Rezoning Transportation Analysis

Petition Number: 2023-070

Date	Description
9-28-23	First Review (TM)

SITE PLAN
 NEIGHBORHOOD COMMERCIAL CENTER

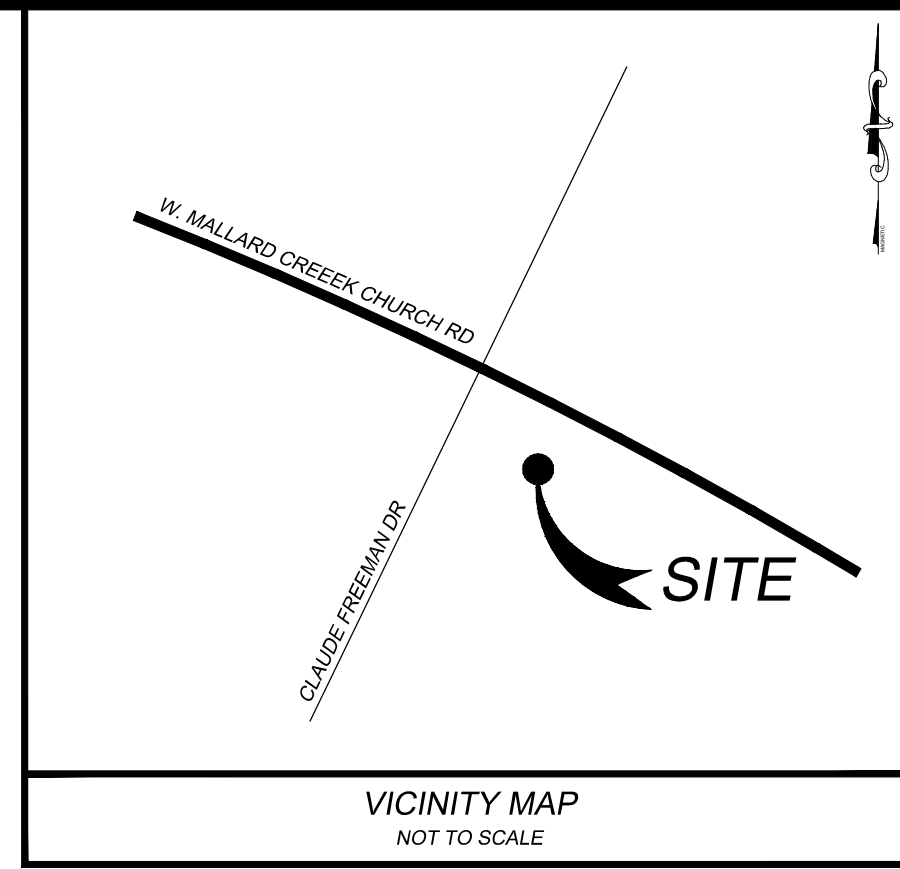
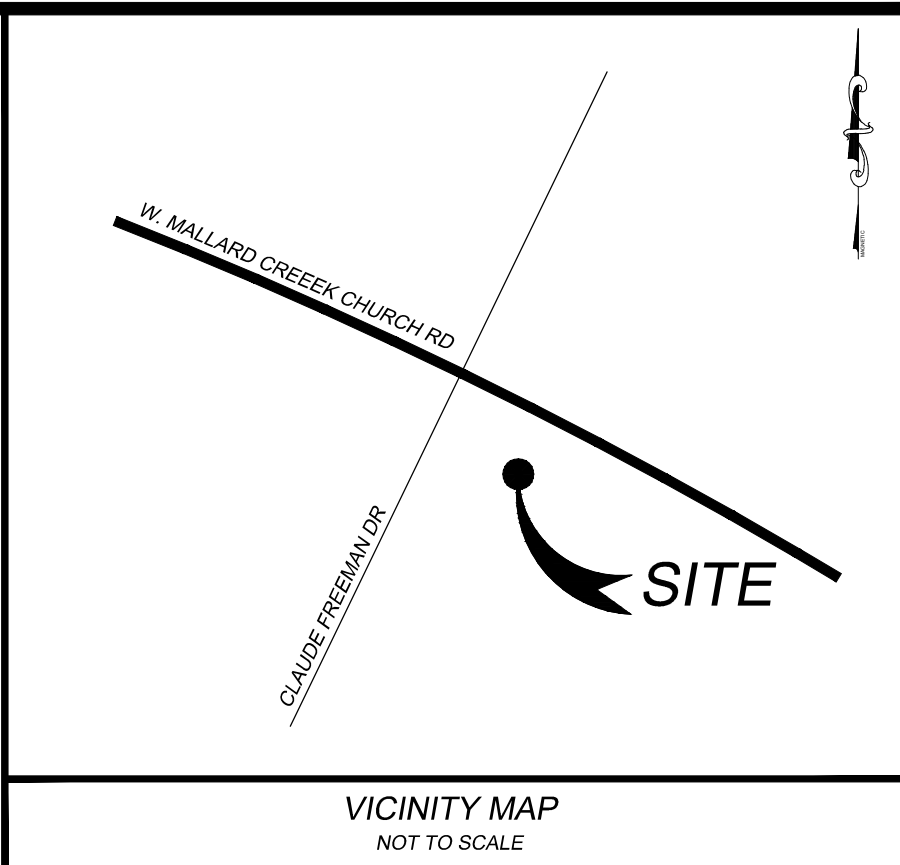
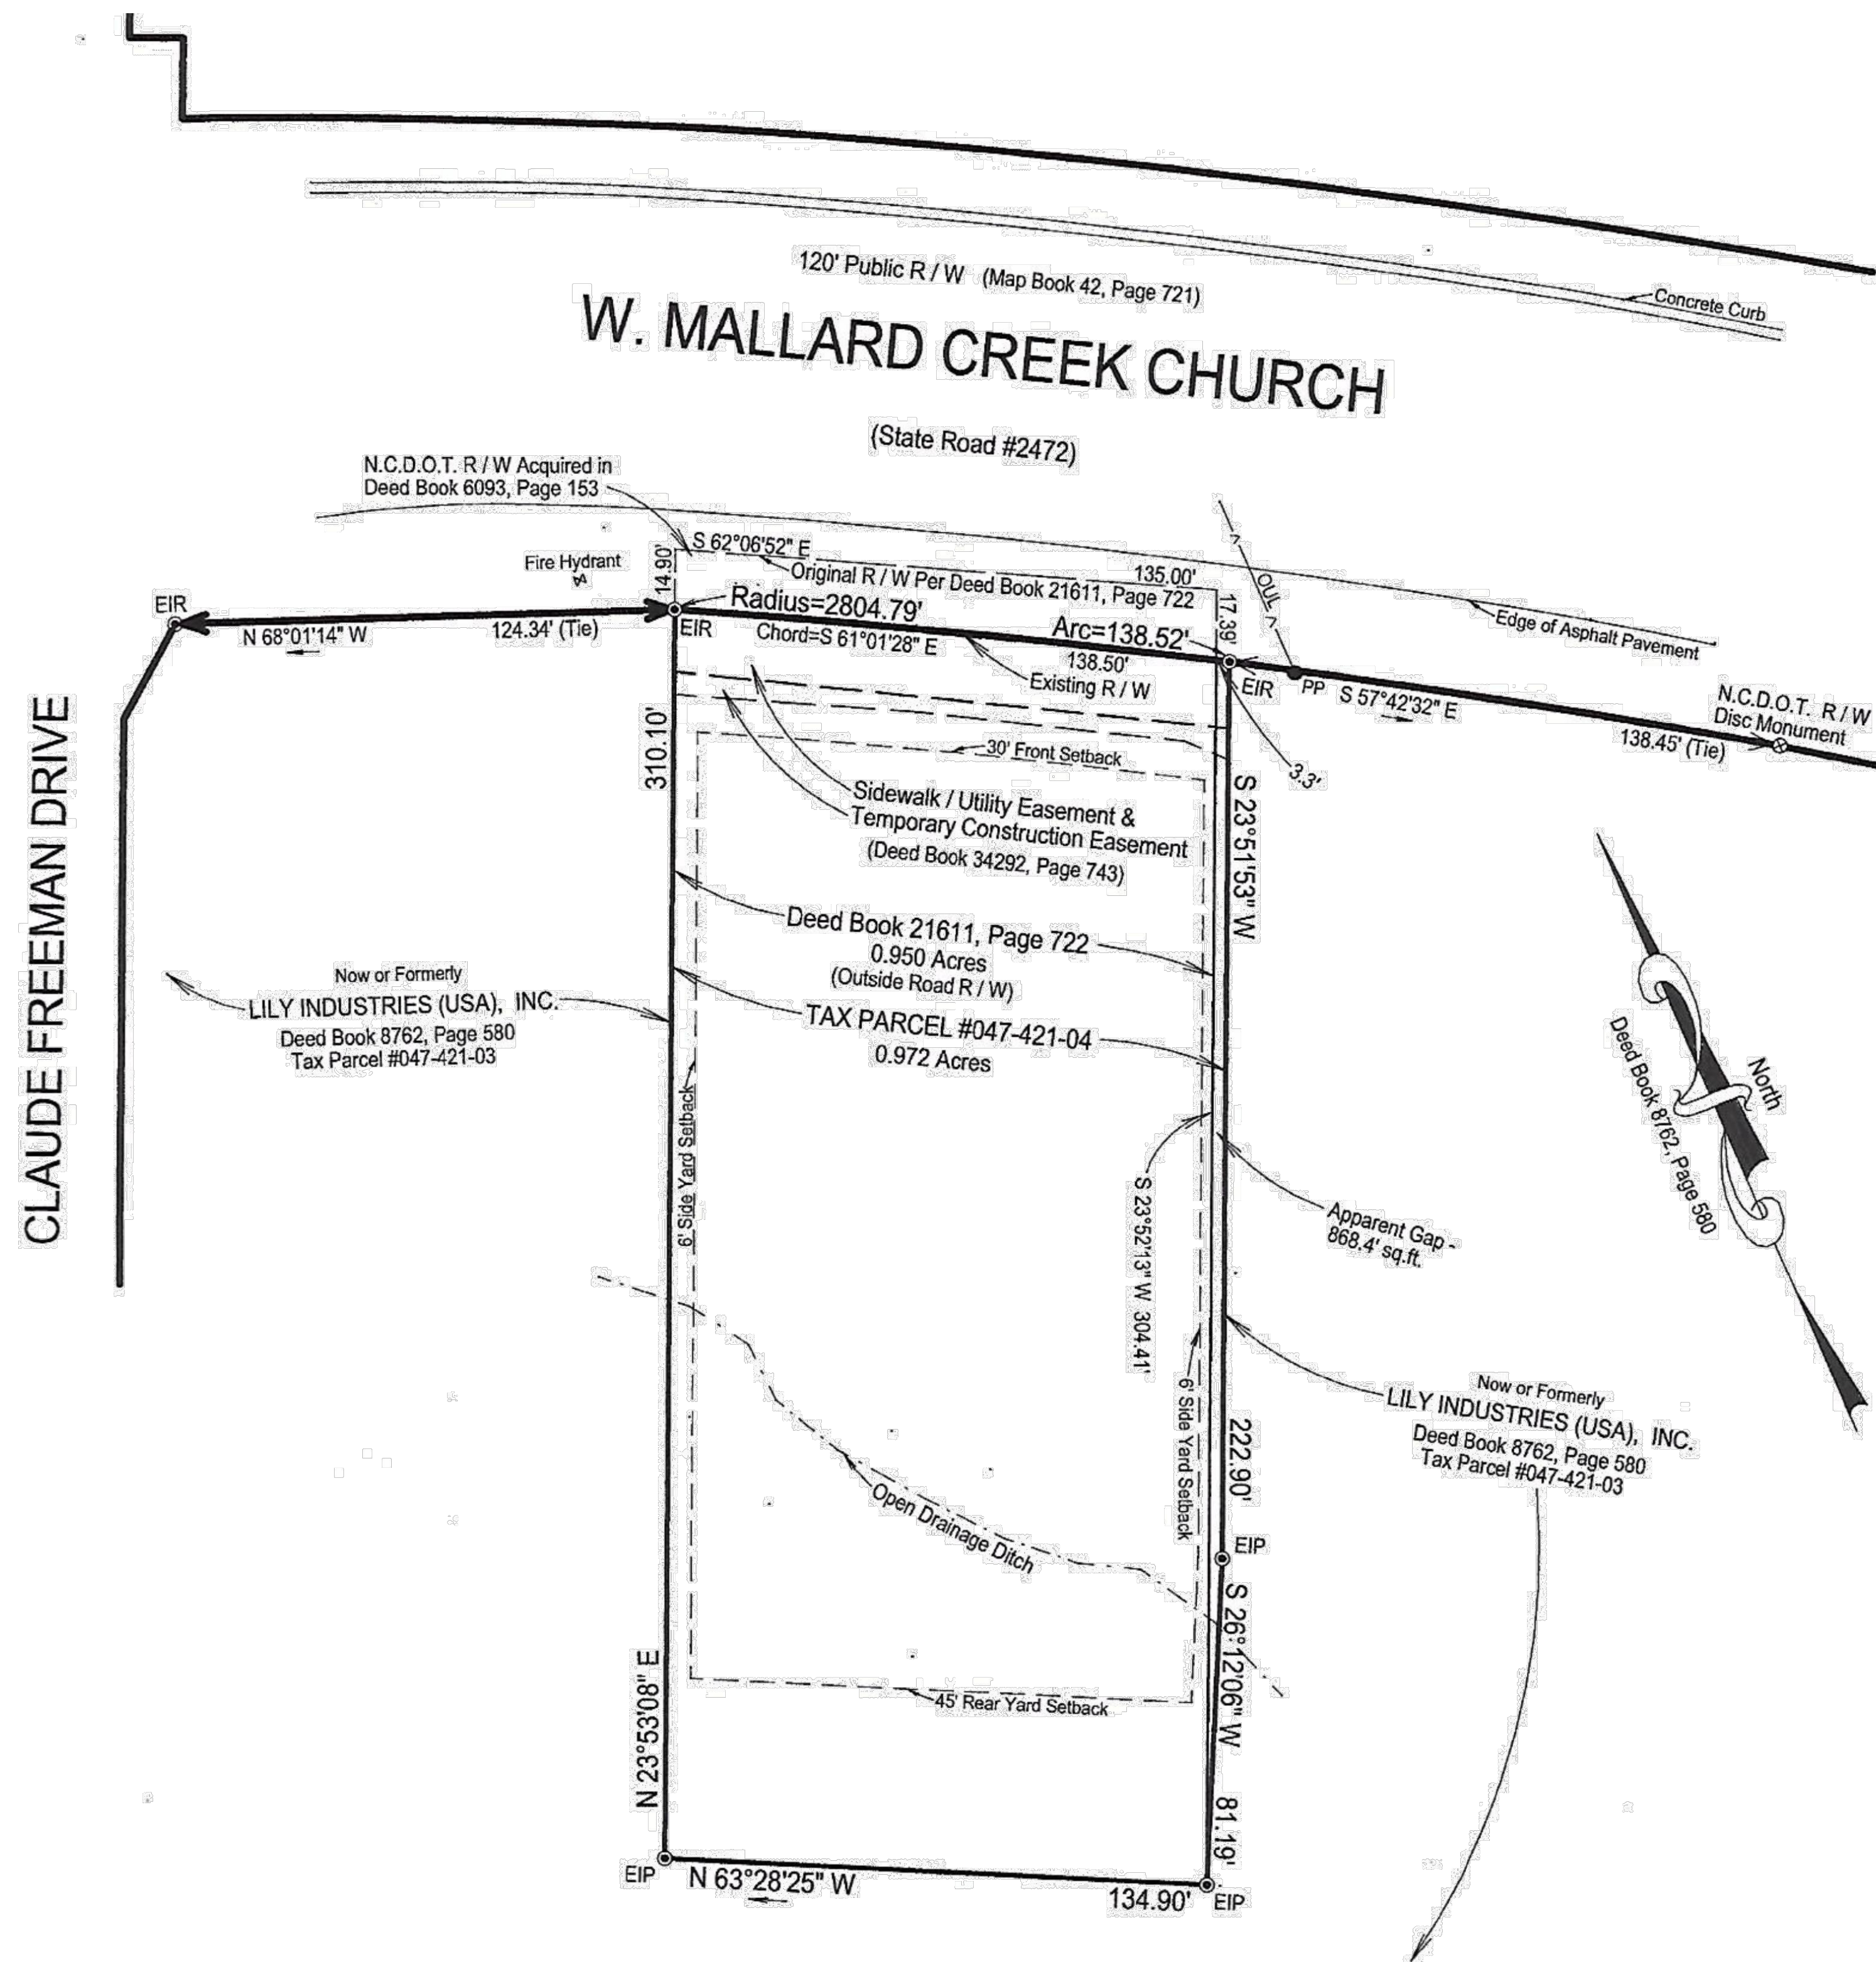
Mallard Creek Church Road: Location of curb and gutter is to be constructed at 33-feet from roadway centerline.

Label and dimension the curb and gutter from the centerline for each road on the site plan.

3. Revise site plan and conditional note(s) to commit to dedicate 50-feet of right-of-way from the road centerline. The site plan shall label and dimension the right-of-way from the road centerline.

4. Revise site plan and conditional note(s) to commit to cross-access to both adjacent parcels to meet minimum UDO requirements regarding parcel access in Chapter 31.2 of the UDO.

CDOT REQUESTS petitioner add sidewalk accommodations at both cross-access locations to promote future pedestrian connectivity.

5. Revise site plan and conditional note(s) to commit to providing a 50-foot driveway stem measured from the edge of pavement along Mallard Creek Church Road in coordination with NCDOT.
6. Revise site plan and conditional note(s) to commit to removing the raised pork chop median from site plan access on Mallard Creek Church Road. Mallard Creek Church Road is currently a right in right out due to the existing median.
